From: Jonathan Fletcher
Sent: 24 January 2017 11:55
To: DCAdmin
Subject: FW: 2016/94058 Southfield, Homfirth, HD9 7LX

From: Joe Robertson
Sent: 09 January 2017 15:34
To: Jonathan Fletcher
Subject: 2016/94058 Southfield, Homfirth, HD9 7LX

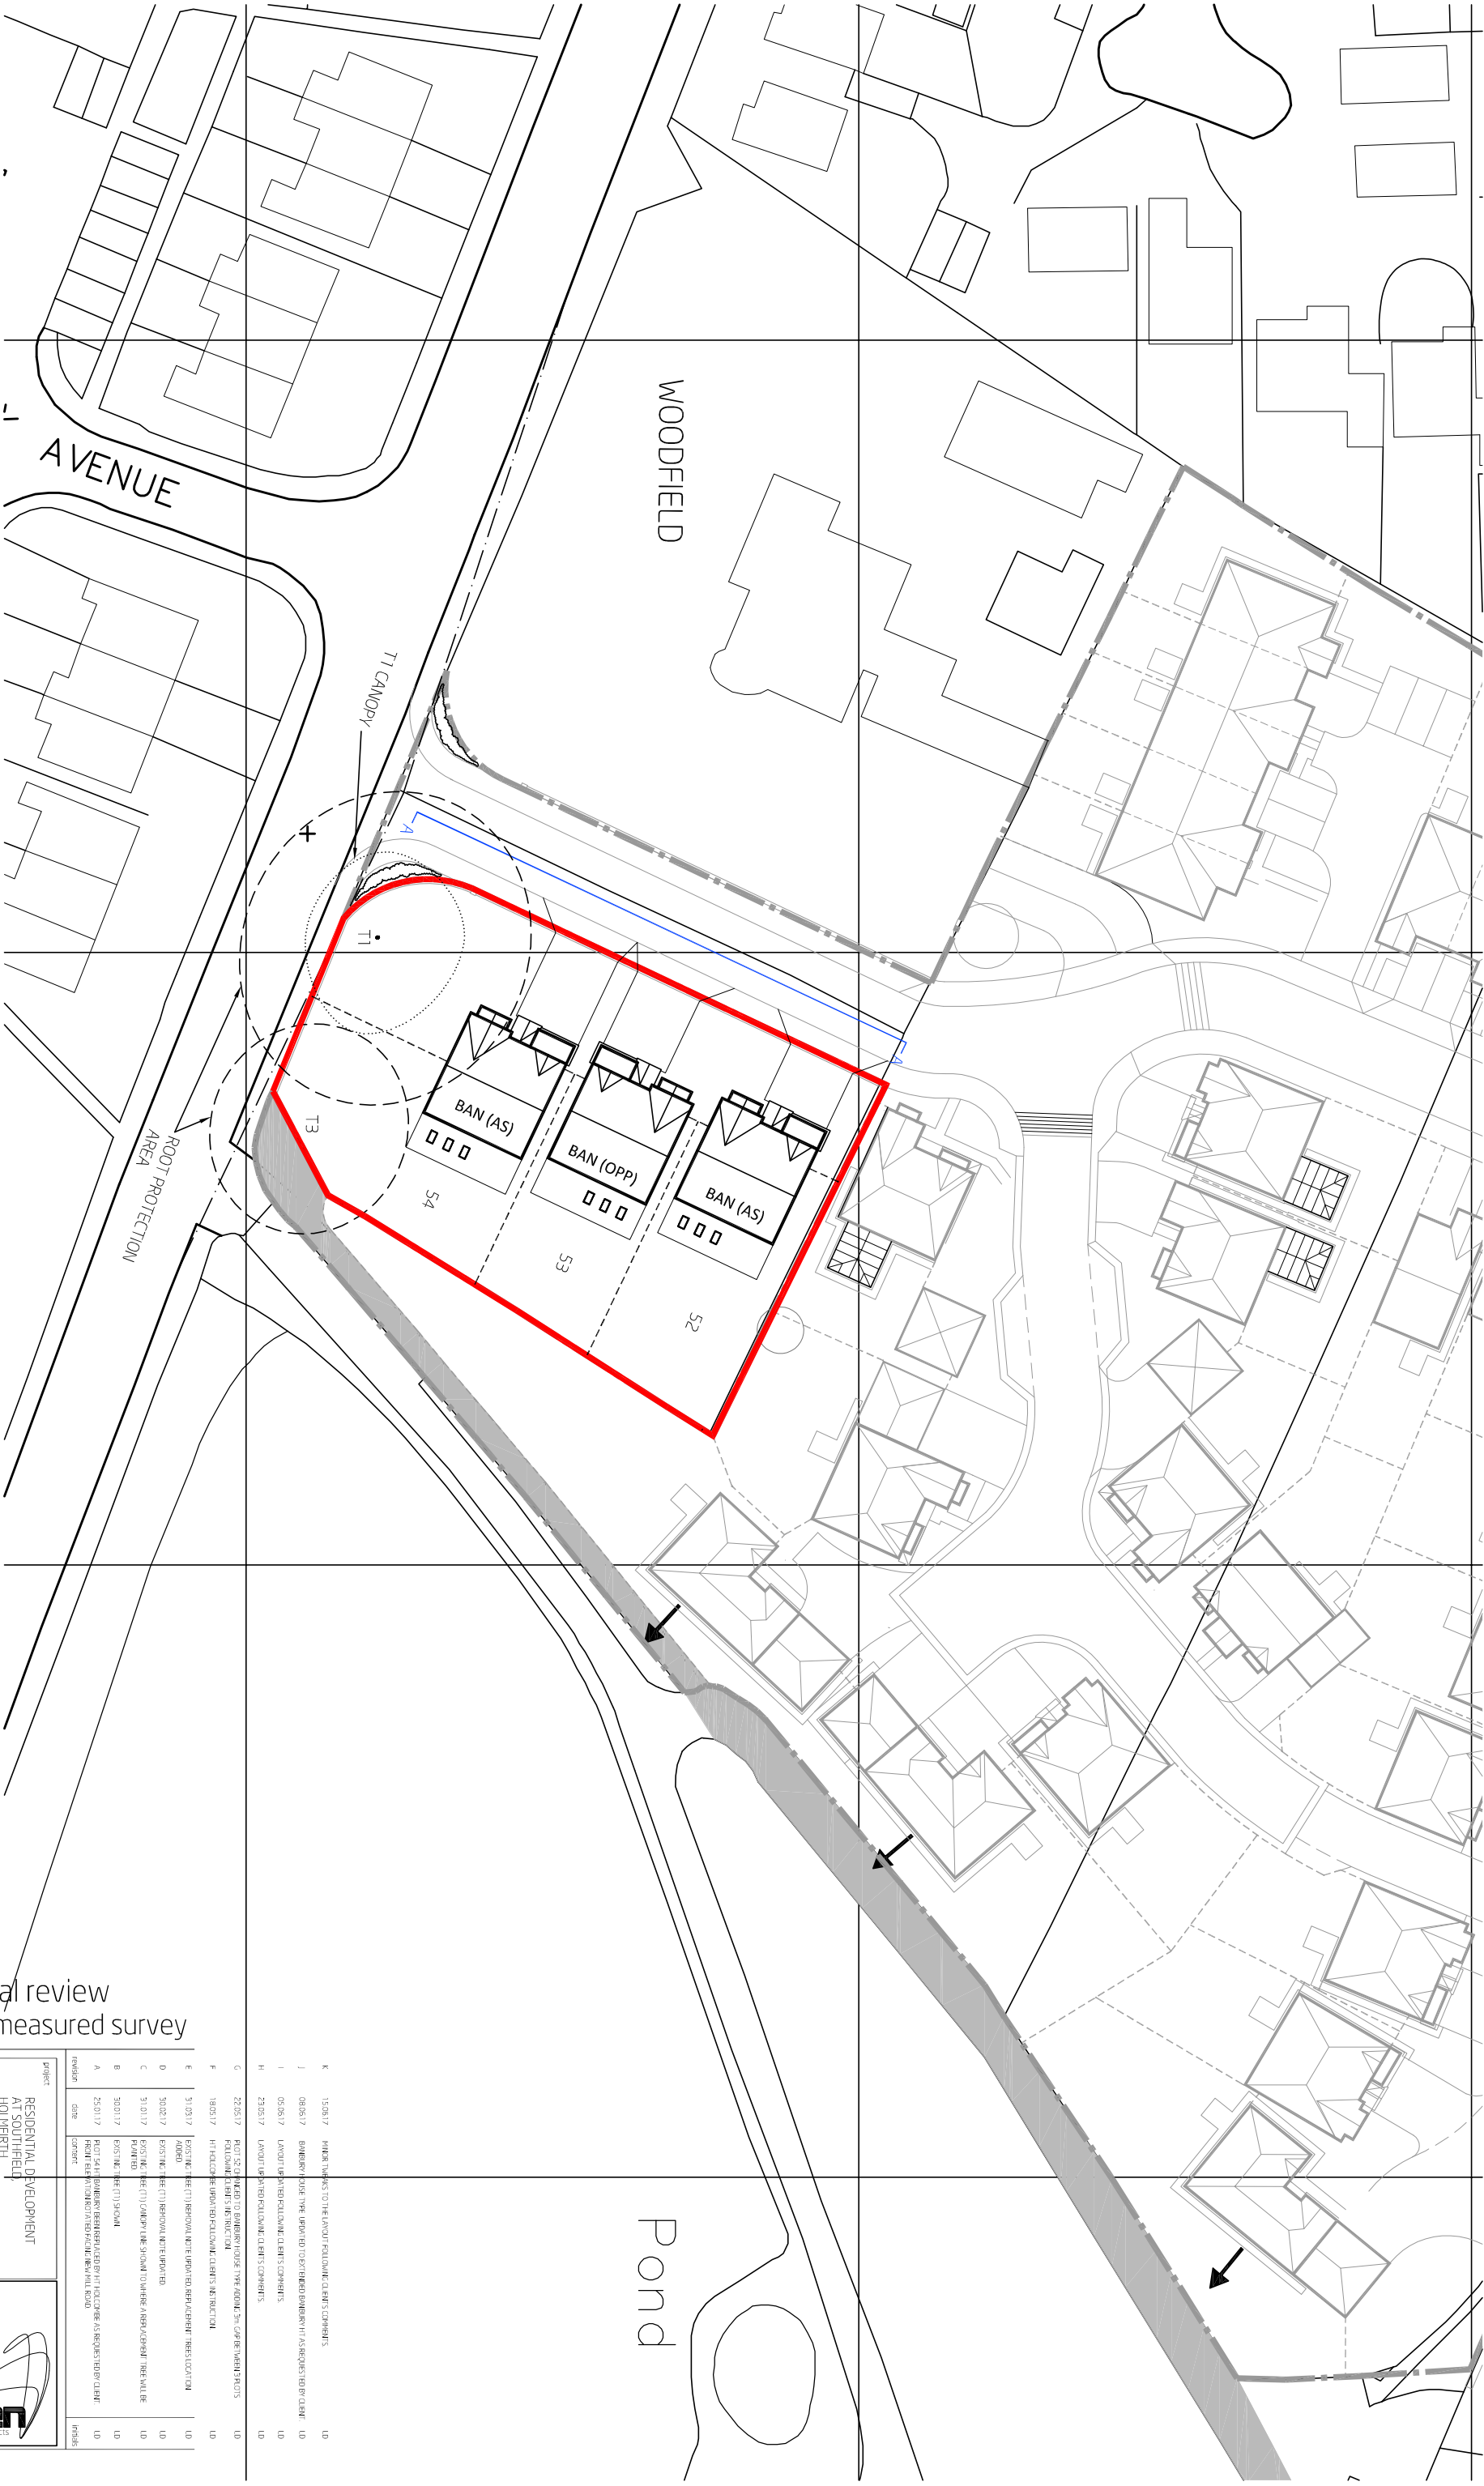
The trees info submitted shows T1- Chestnut to be felled. While the tree survey data has identified points to monitor on this tree, the report's recommendations are to remove the tree 'to facilitate the development' and not for arboricultural reasons.

This tree is protected by a TPO 02/06, it is a prominent feature when viewed from the road, and makes a significant contribution to the aesthetics and character of the locality. For this reason I can not support its loss to facilitate the development.

I do not believe the retention of T1 will stop development on site, however I can not support the current proposal of three dwellings which will require the loss of this tree.

As it stands I consider that the current proposal does not meet UDP policy NE9 'mature trees should be retained' and BE2 'existing trees to be incorporated as an integral part of the proposal'
